RE: Planning Application - AW/251/20/OUT – 14 Princess Avenue – Aldwick

Please take this letter as formal notice of our strong objection to the above planning application which seeks to convert an existing single family dwelling into four flats.

Proposed Site Layout Plan at 1:100 scale

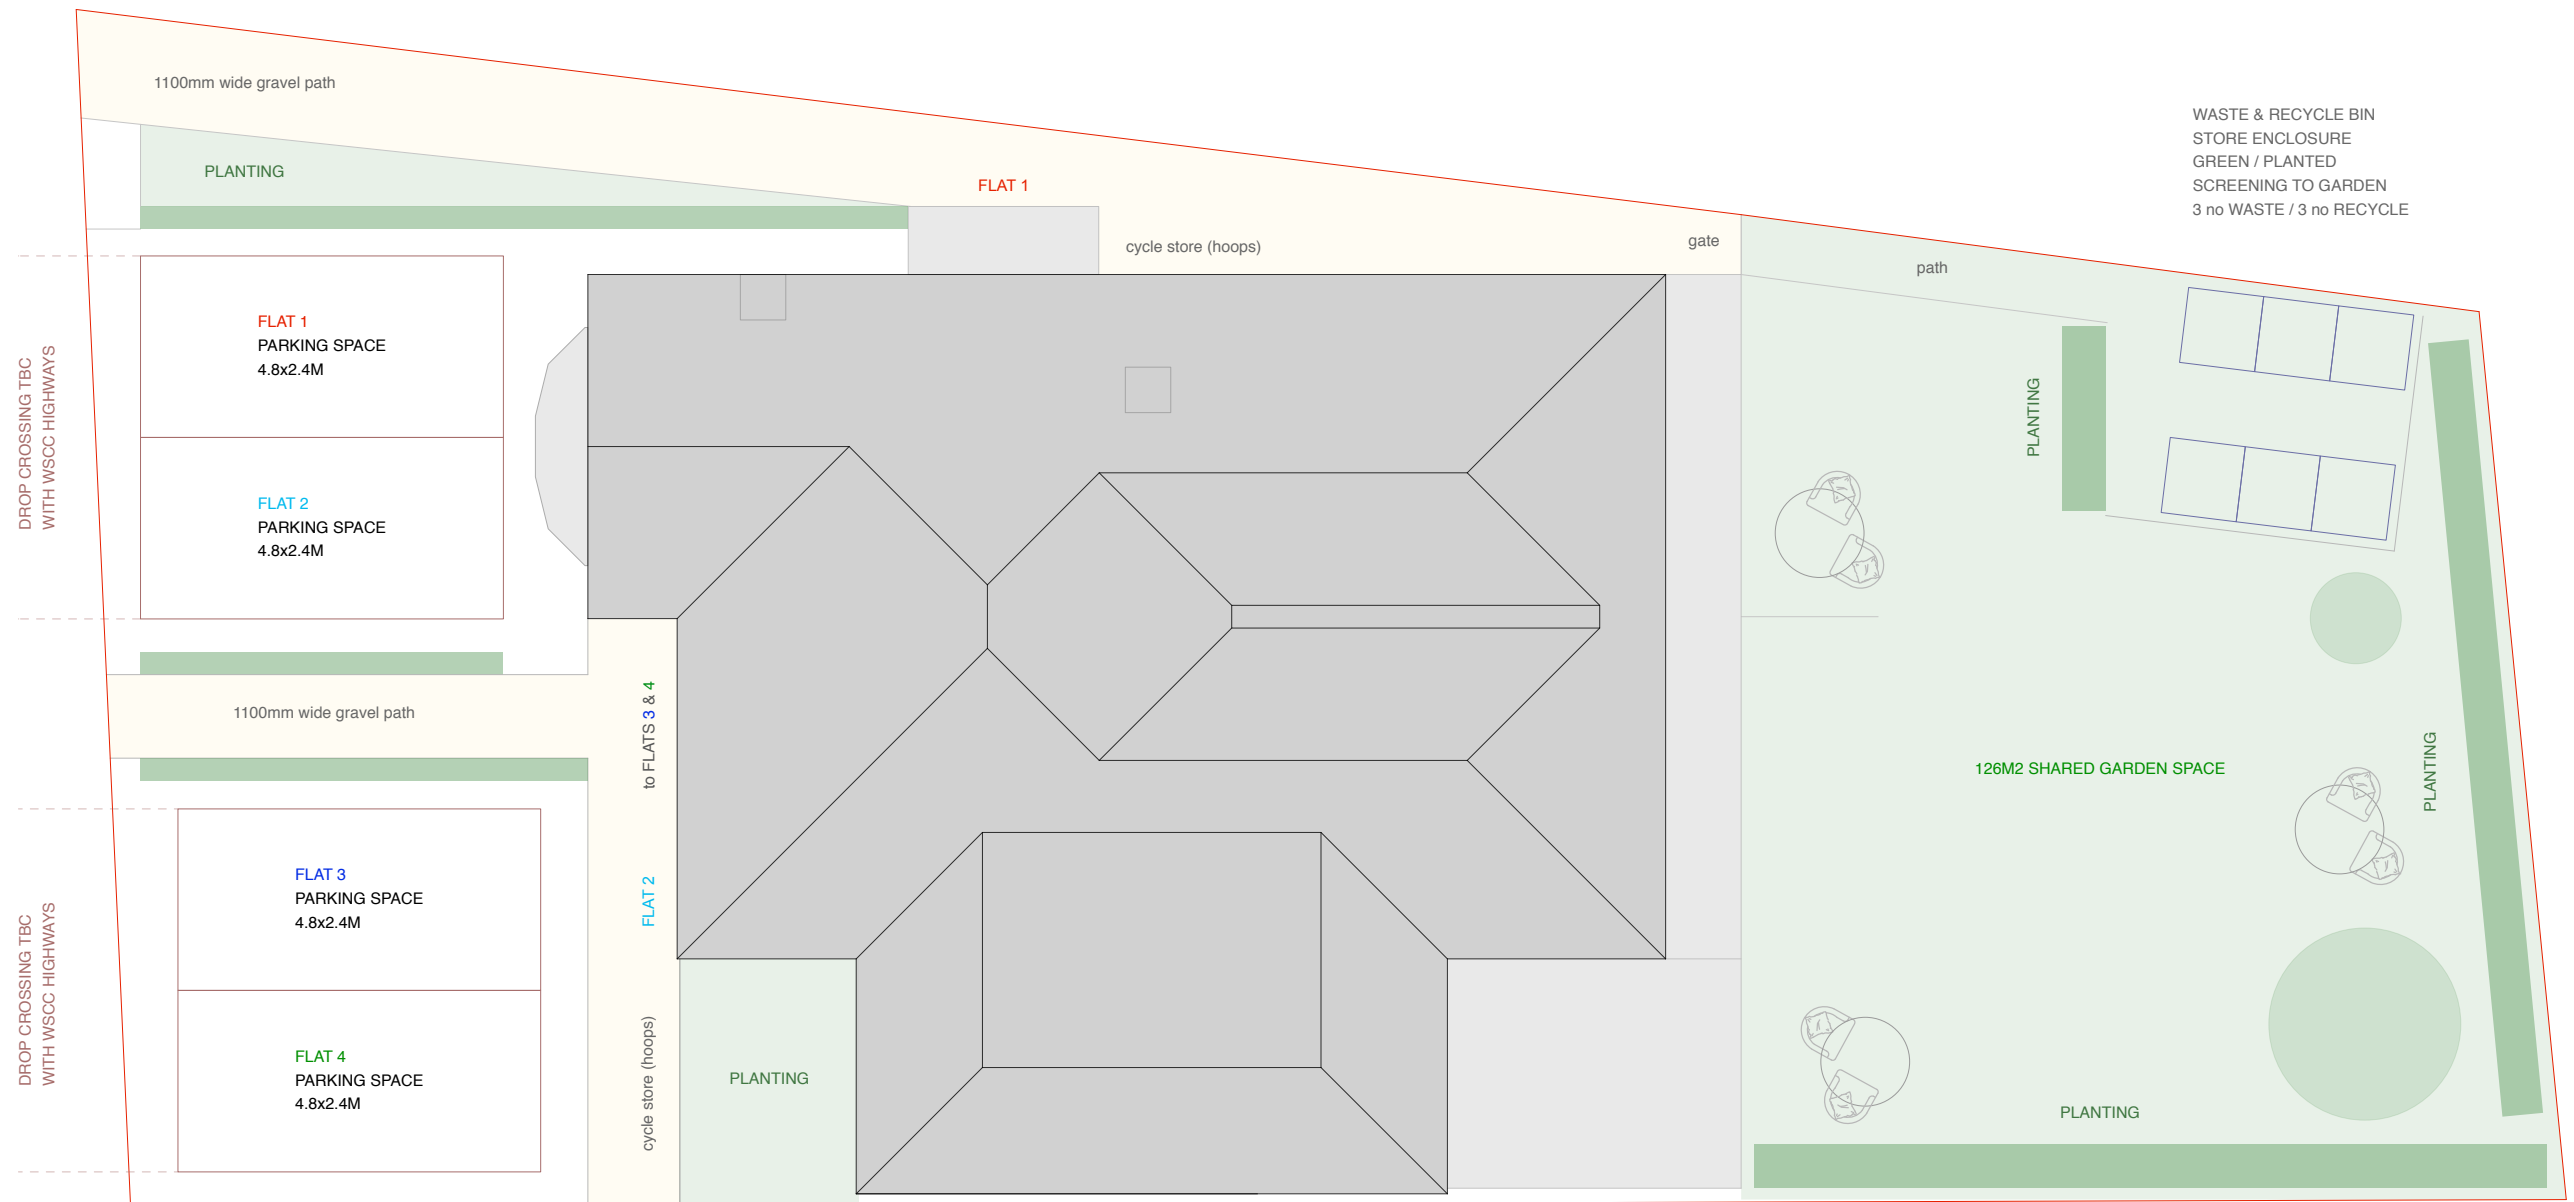
In support of their application the Applicant has submitted a Drawing No 8 - Proposed Site Layout Plan. The drawing shows at the northern side of the ‘Shared Garden Space’ a Waste and Recycle Bin Store.

Each week the occupants of the four flats will be required to take four black Waste Bins from the bin store in the rear garden to the road frontage of 14 Princess Avenue and back. Each single bin journey will be twenty-eight metres from bin store to road. The round trip for each bin will therefore be some fifty-six metres or 280 metres for all five bins.

Every second week the occupants will manhandle 8 bins – Waste and Recycling- from the bin store in the rear garden to the road and back. This will generate a collective noise undoubtedly in excess of the 97 Decibel figure. This noise will far exceed the ‘over 72 decibel’ level of Noise Exposure Category D – the level where planning permission should normally be refused.

There are trees in both front and rear gardens at 14 Princess Avenue. It is clear from Drawings 8 - Proposed Site Layout Plan from both front and rear gardens that all trees and grass are to be removed in order to 'Tarmac over' the whole of the front garden for car parking which is counter to the character and appearance of the area. In the rear garden the trees next to the north wall of the garden will need to be completely removed in order to build the Waste Bin Store and the Cycle Store as shown in Drawing No 8 – Site Plan.

CLIENT	Mrs B Woodland	DRAWING	002 Proposed Floor Plans
SITE	14 Princess Avenue, Aldwick	DATE	10 09 20
PROJECT	Proposed Conversion to Flats	SCALE	1: 100 @ A3
		AUTHOR	AH
		STATUS	DRAFT

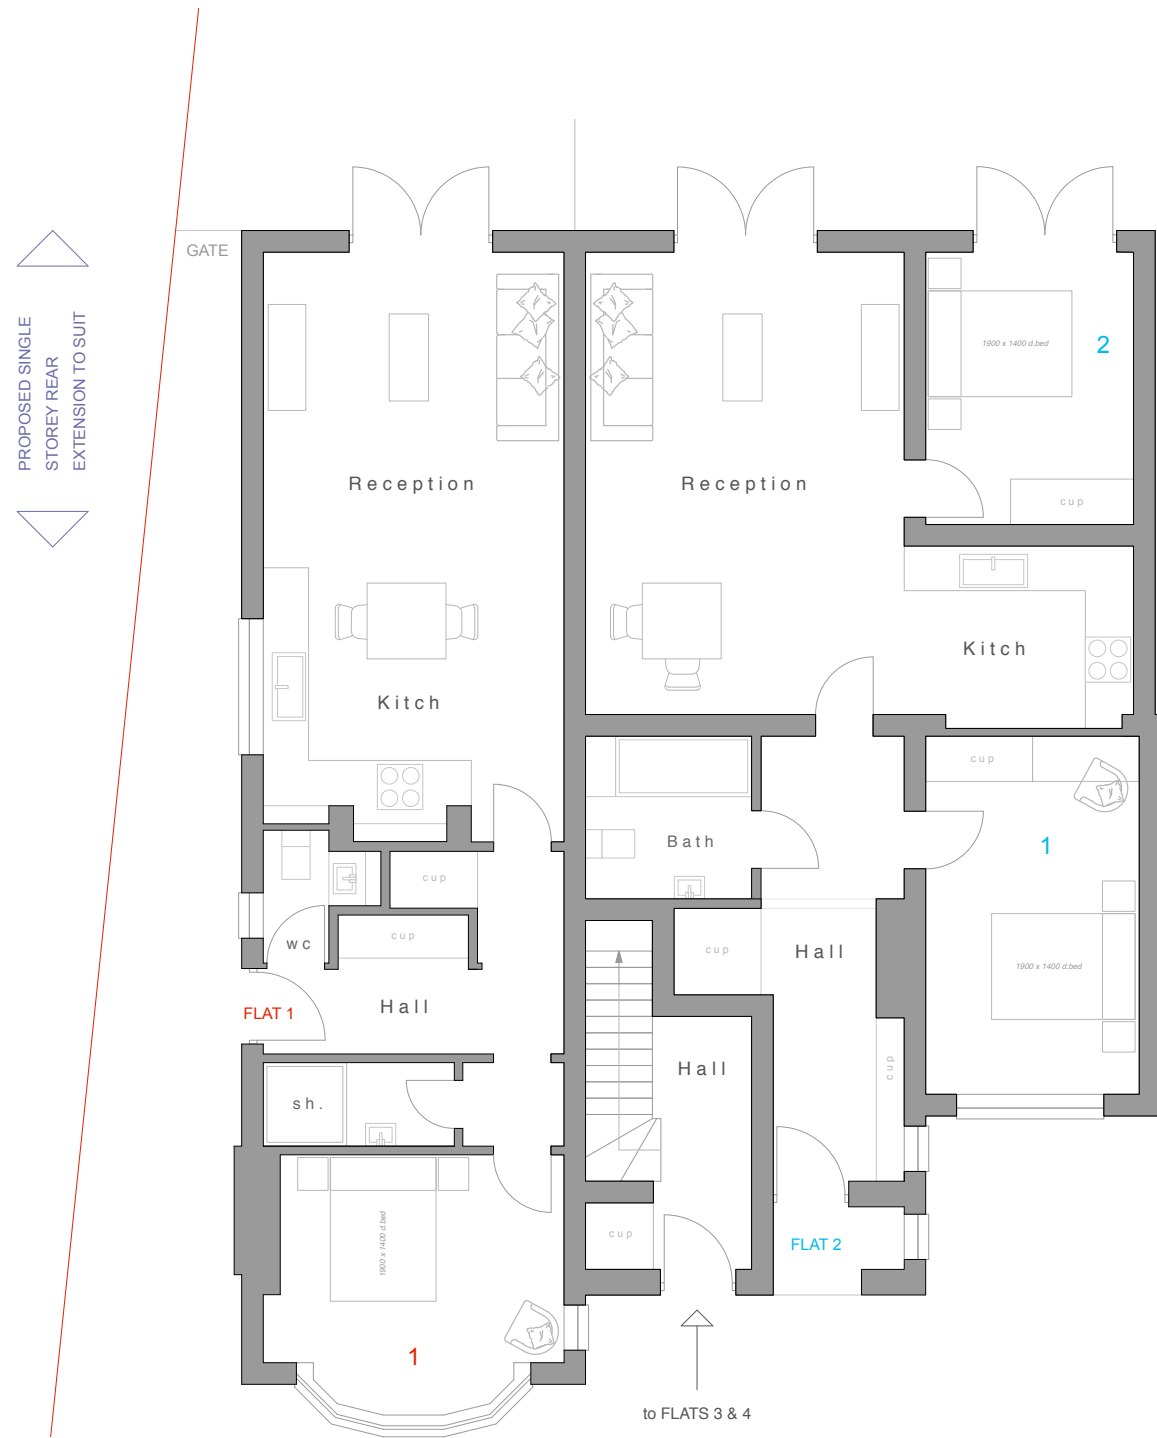
Examination of Drawings Nos. 2 and 4 – Proposed Ground Floor Plan and rear elevation South East shows that patio doors to the garden are proposed for the reception rooms and of Ground Floor Flats 1 & 2 and for the rear bedroom of Flat 2. There will inevitably be movement and noise from the back of the proposed development. Currently there is no such activity or noise and neighbouring properties enjoy quiet at the rear of their properties with neither sound nor lighting at night. Our experience has been, with Sandringham Wessex Avenue where similar patio doors have been fitted, unsympathetic use of Hi-Fi equipment has caused a significant noise nuisance problem, which was not there before the patio doors were fitted. Arun D C Ref. SR/239713 Ms Joanne Lewis -Anti-Social Behaviour, Crime and Policing Act 2014 Section 43
